To: Michael Czarnieki **From:** Mike Nugent

Fax: 947-4628 **Date:** July 16, 2004

Re: 57 Commercial St. (029 K003)

Drawing file: 040048 plans / ae301.PDF

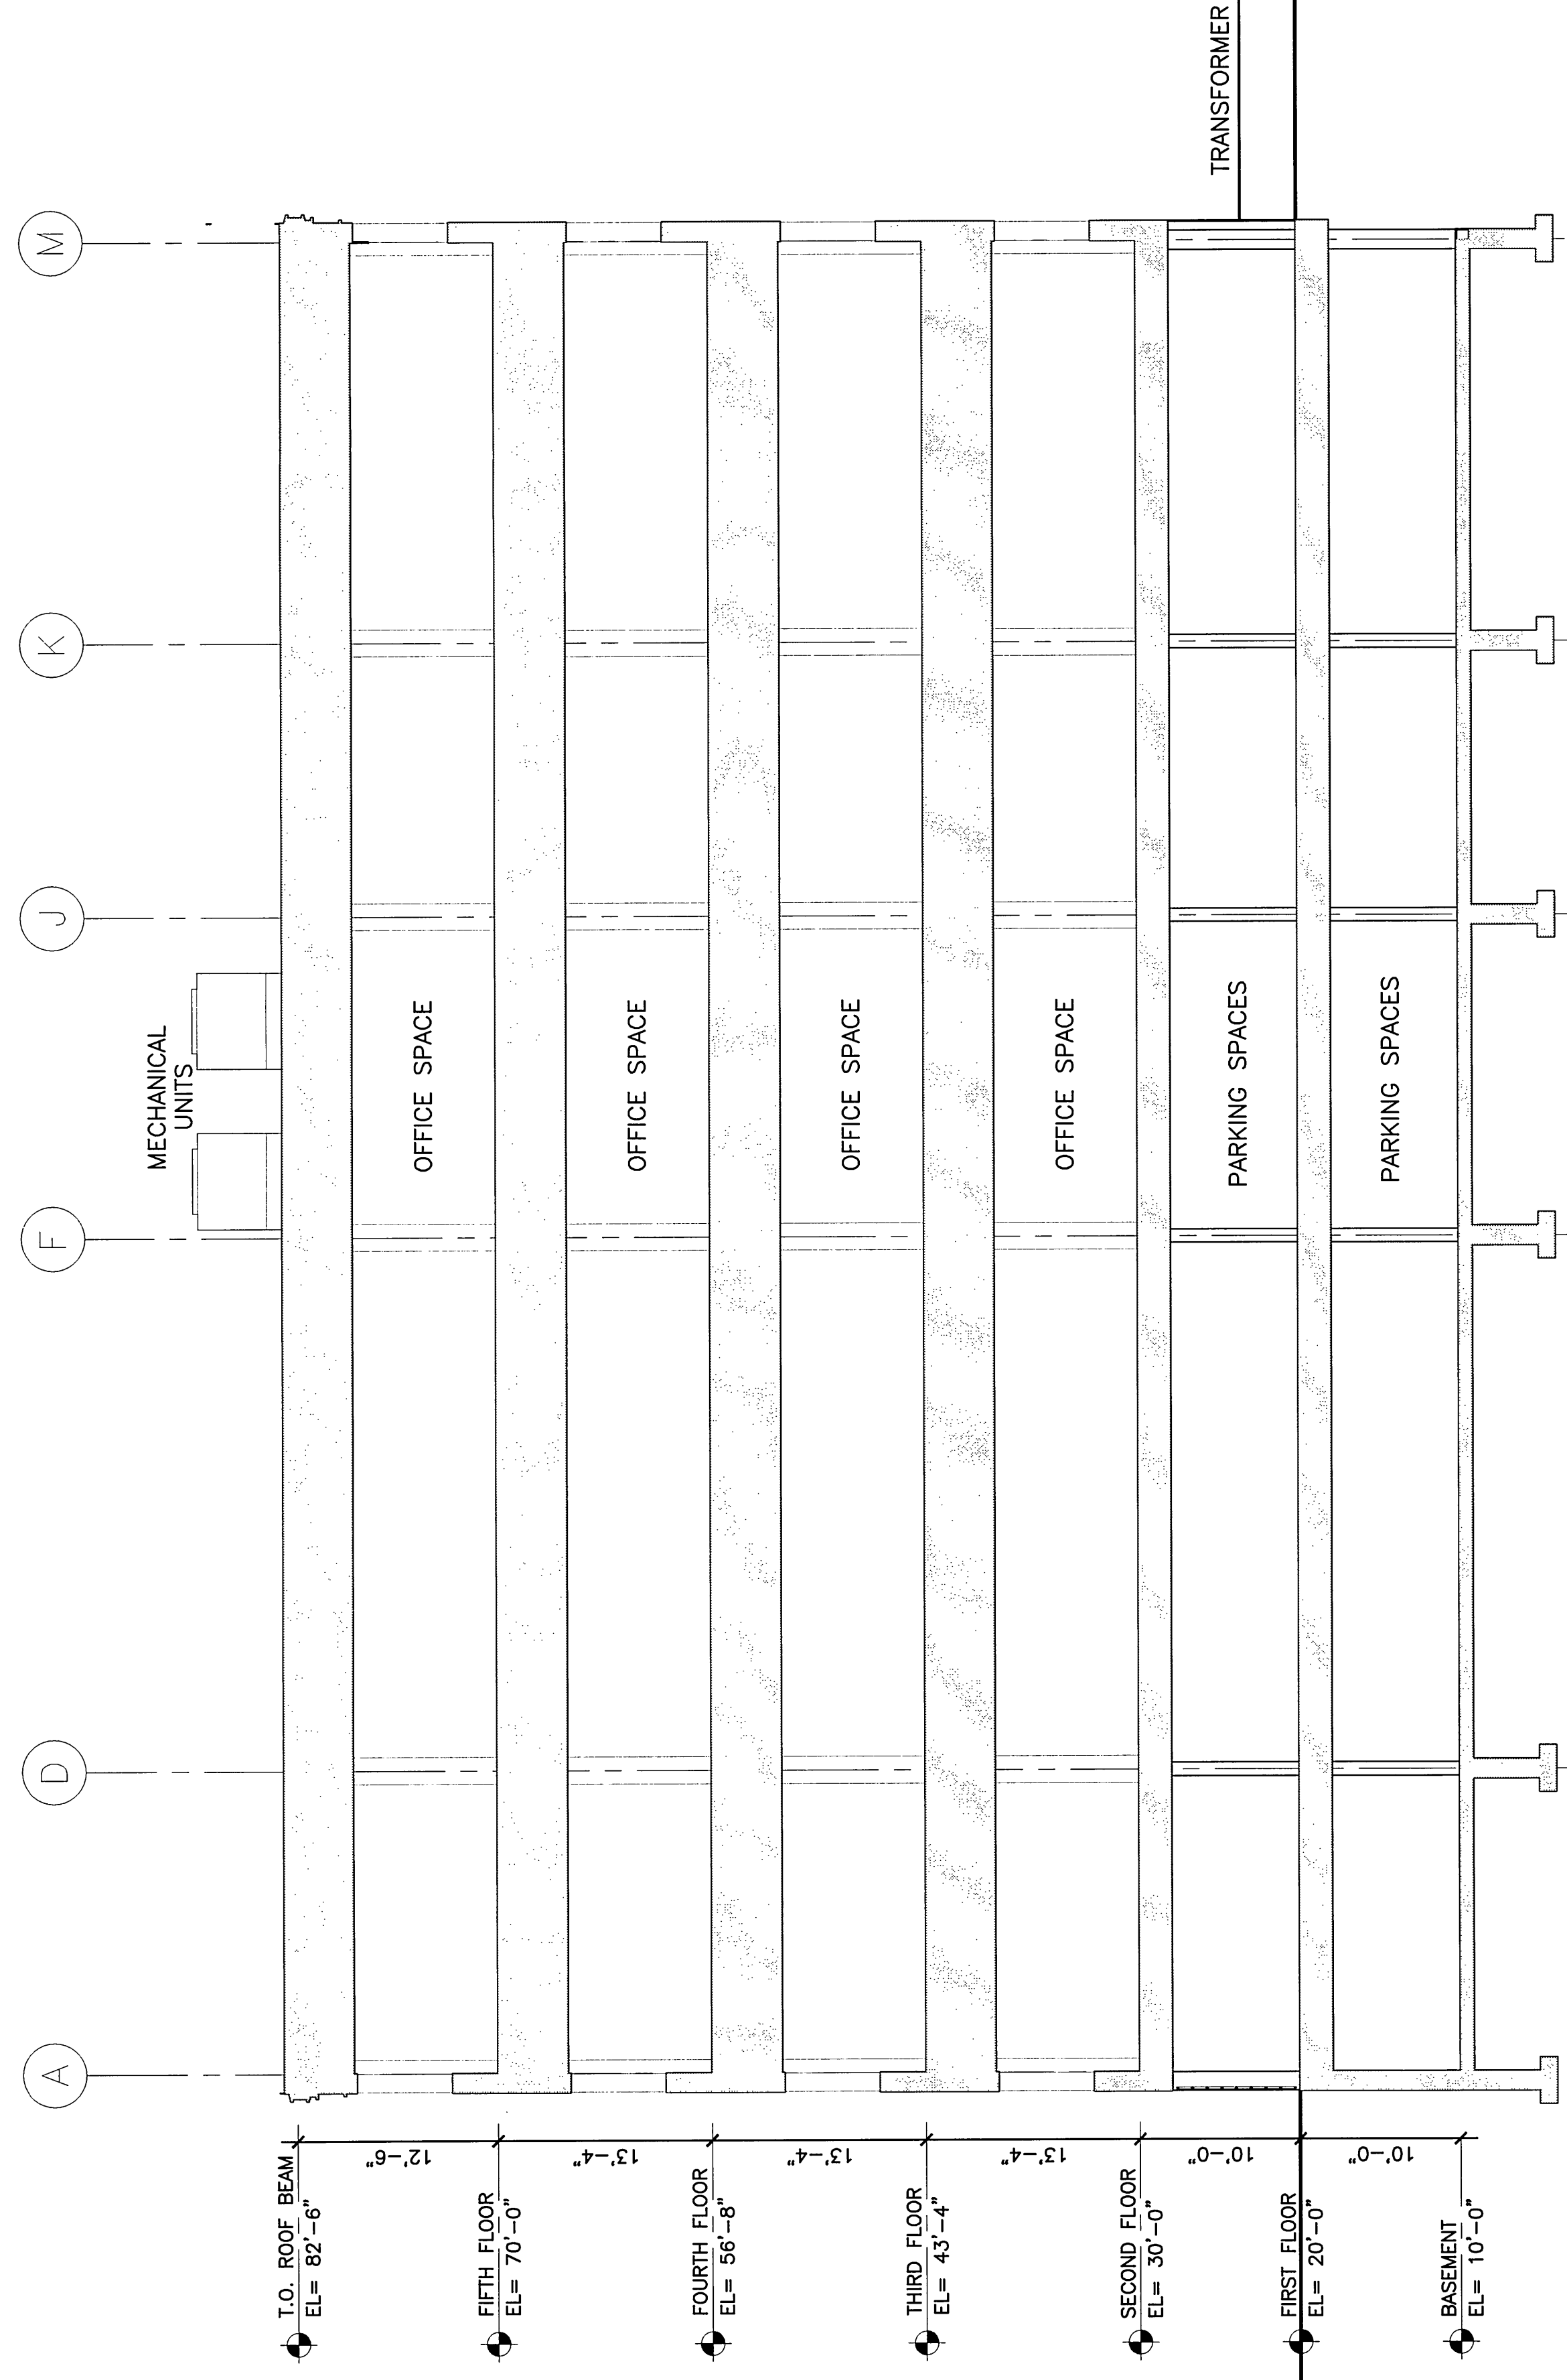
- 1) Several pages of the plans are not stamped.
- 2) Page AE301 The Stair width and Guard heights scale differently than the details.
- 3) Please provide a fire rates assembly penetration protection detail for the pneumatic tube system
- 4) Attached is page three of our certification forms, please complete, I'm looking for structural loads for the new stair and lobby area.
- 5) J8 on page AE402 show a handrail on one side of the Stairs only must be on both.
- 6) A8 on page AE402 window within the guard height on the stairway must be Safety Glazing.
